DECISION DELEGATED TO HEAD OF PLANNING

Application No: H16-0437-24 **Applicant:** Country Court Care Ltd

Proposal: Erection of two storey rear extension to provide additional bedrooms, day space, storage, nurses station, assisted bathrooms and additional car parking spaces

Location: Ashwood Nursing Home 43 Spalding Common Spalding

NOTES:	
Phoenix 2-23W (with Elite 2 6x4 chassis)	10.595m
Overall Length	2.530m
Overall Width	3.205m
Overall Body Height	0.410m
Min Body Ground Clearance	2.500m
Track Width	4.00s
Lock to lock time	9.250m
Kerb to Kerb Turning Radius

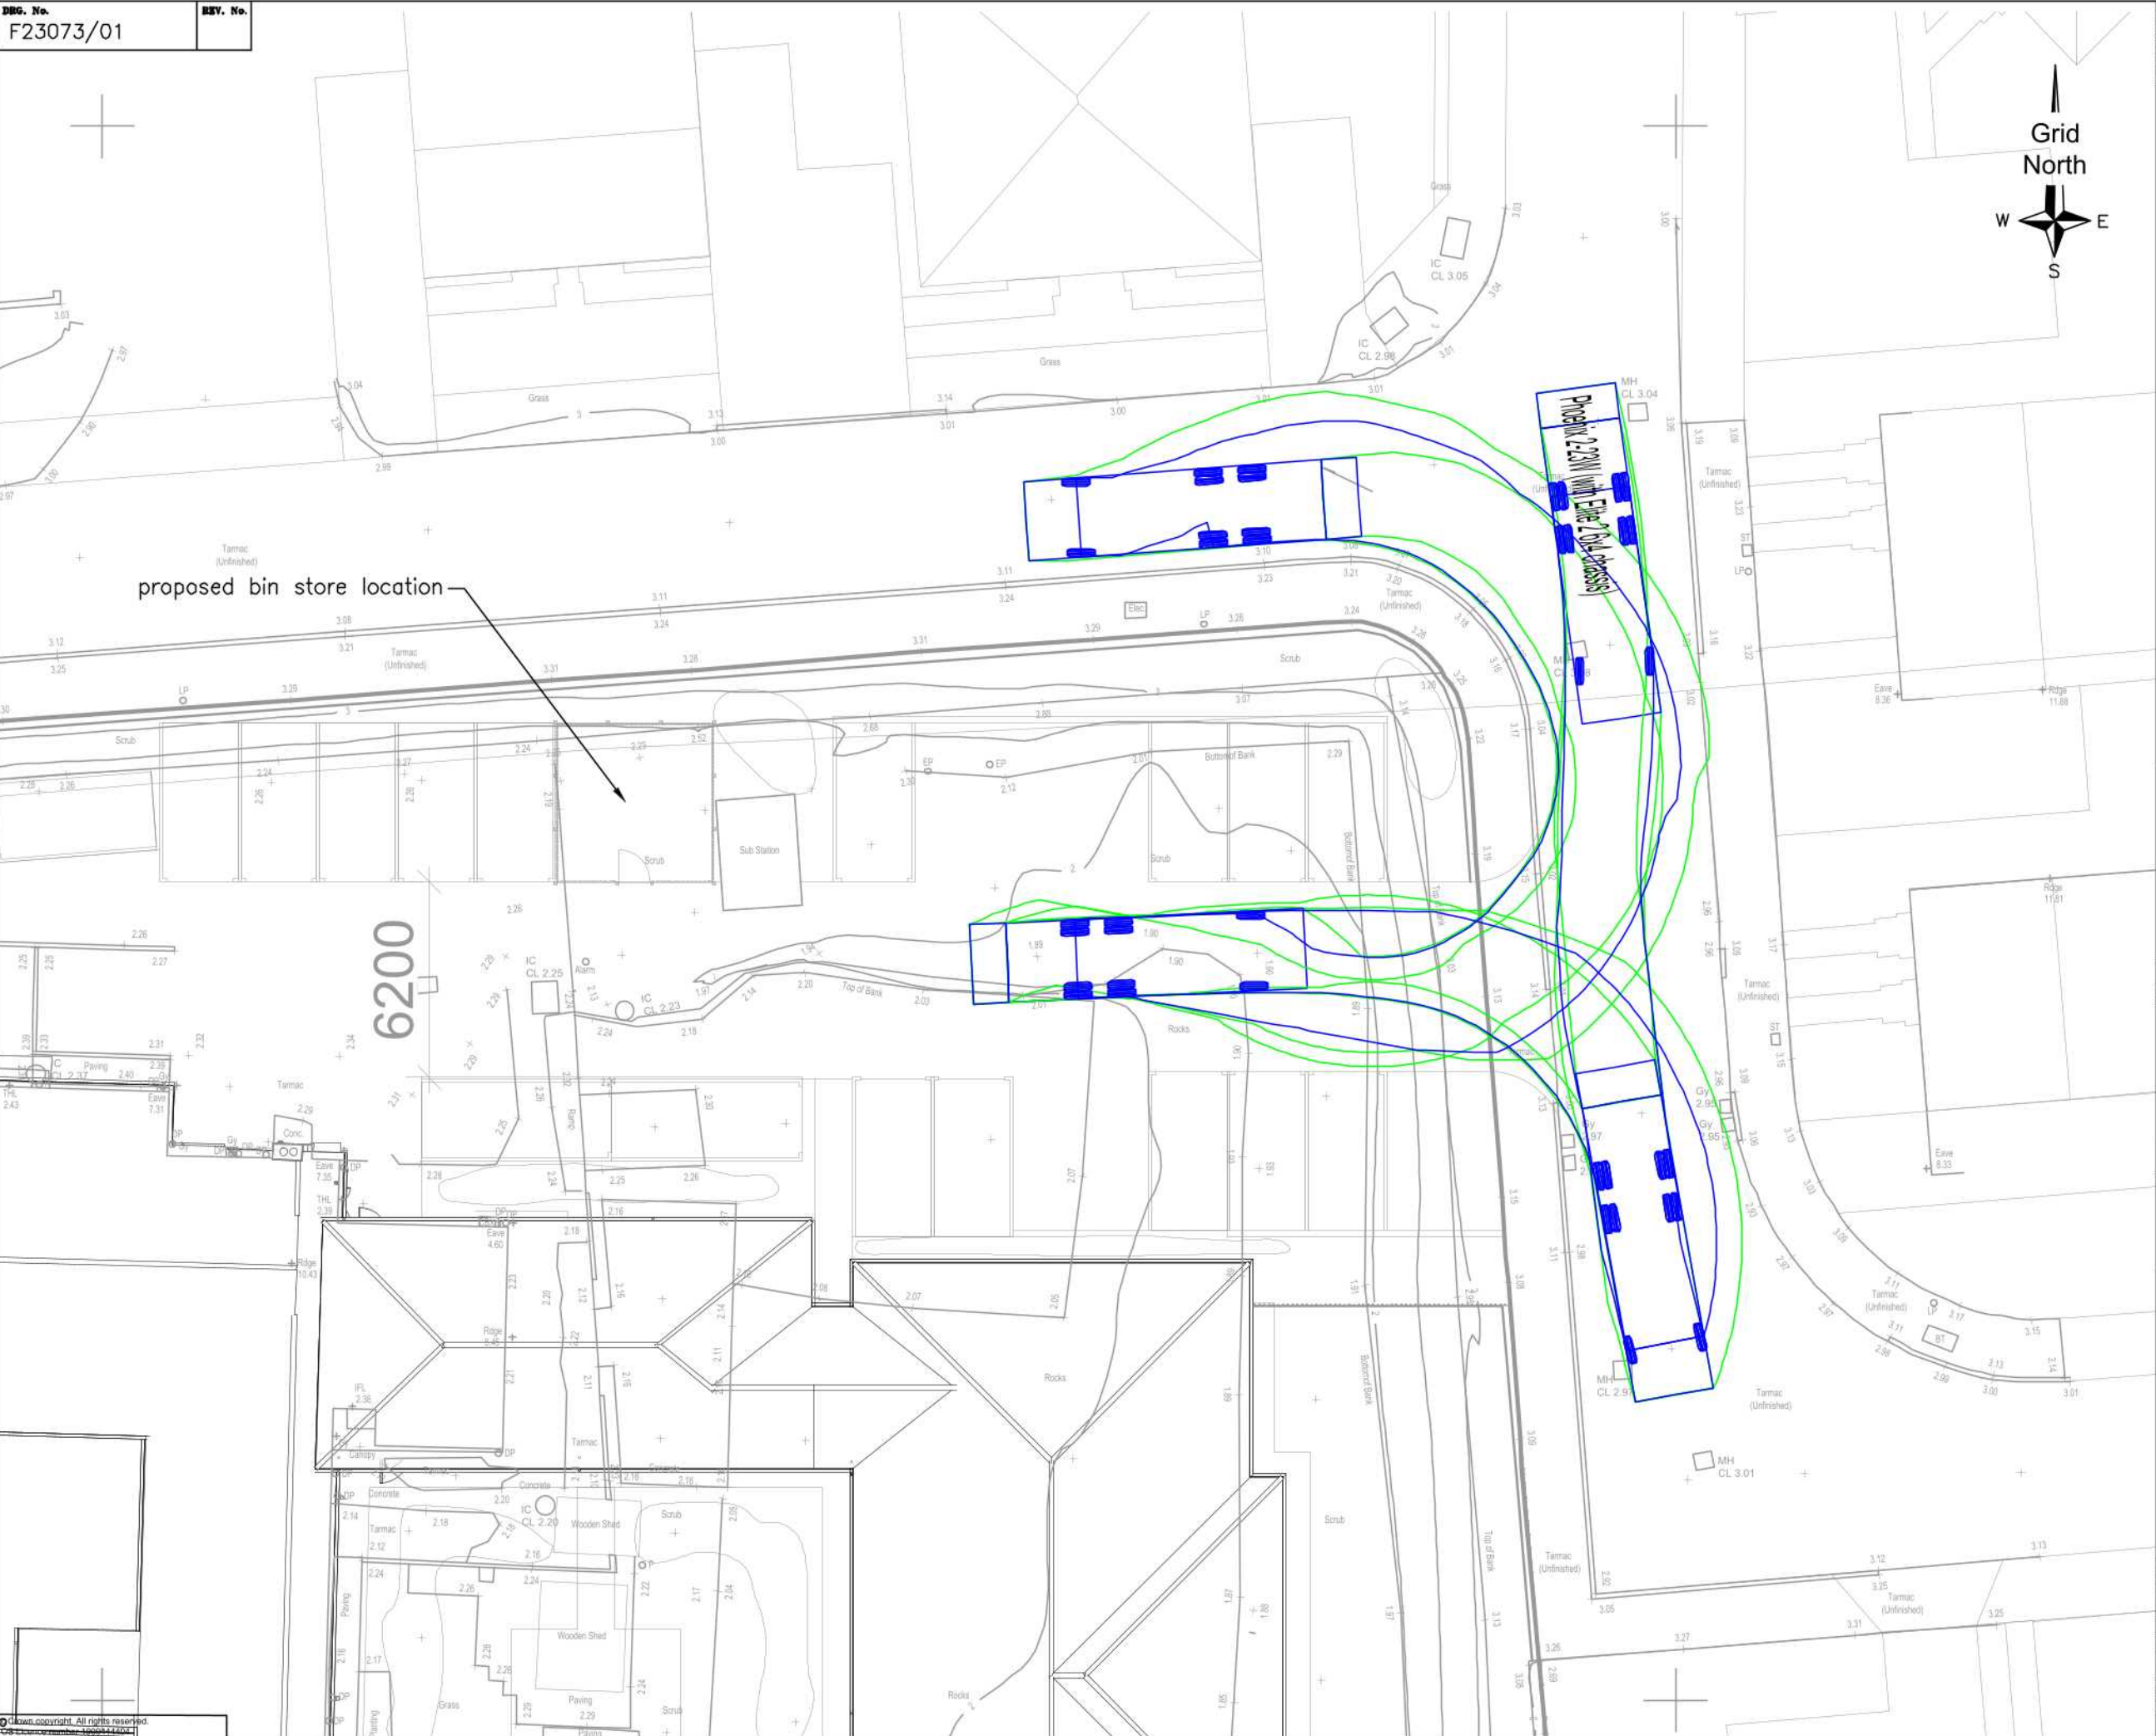
A servicing drawing is required to include a swept path of a pantechican entering and leaving the site in a forward gear. If they are to reverse into the site then they need to be sure that there is enough space without mounting kerbs and the footway opposite the proposed access. The access to the staff car park will be very steep. A note should be added to the drawing to say the proposed accesses will be constructed to Lincolnshire County Council Specification. The Section 38 drawing for the development shows a tactile crossing point where the proposed staff car park access is, it will be for the applicant to amend this with the developer should planning permission be granted.
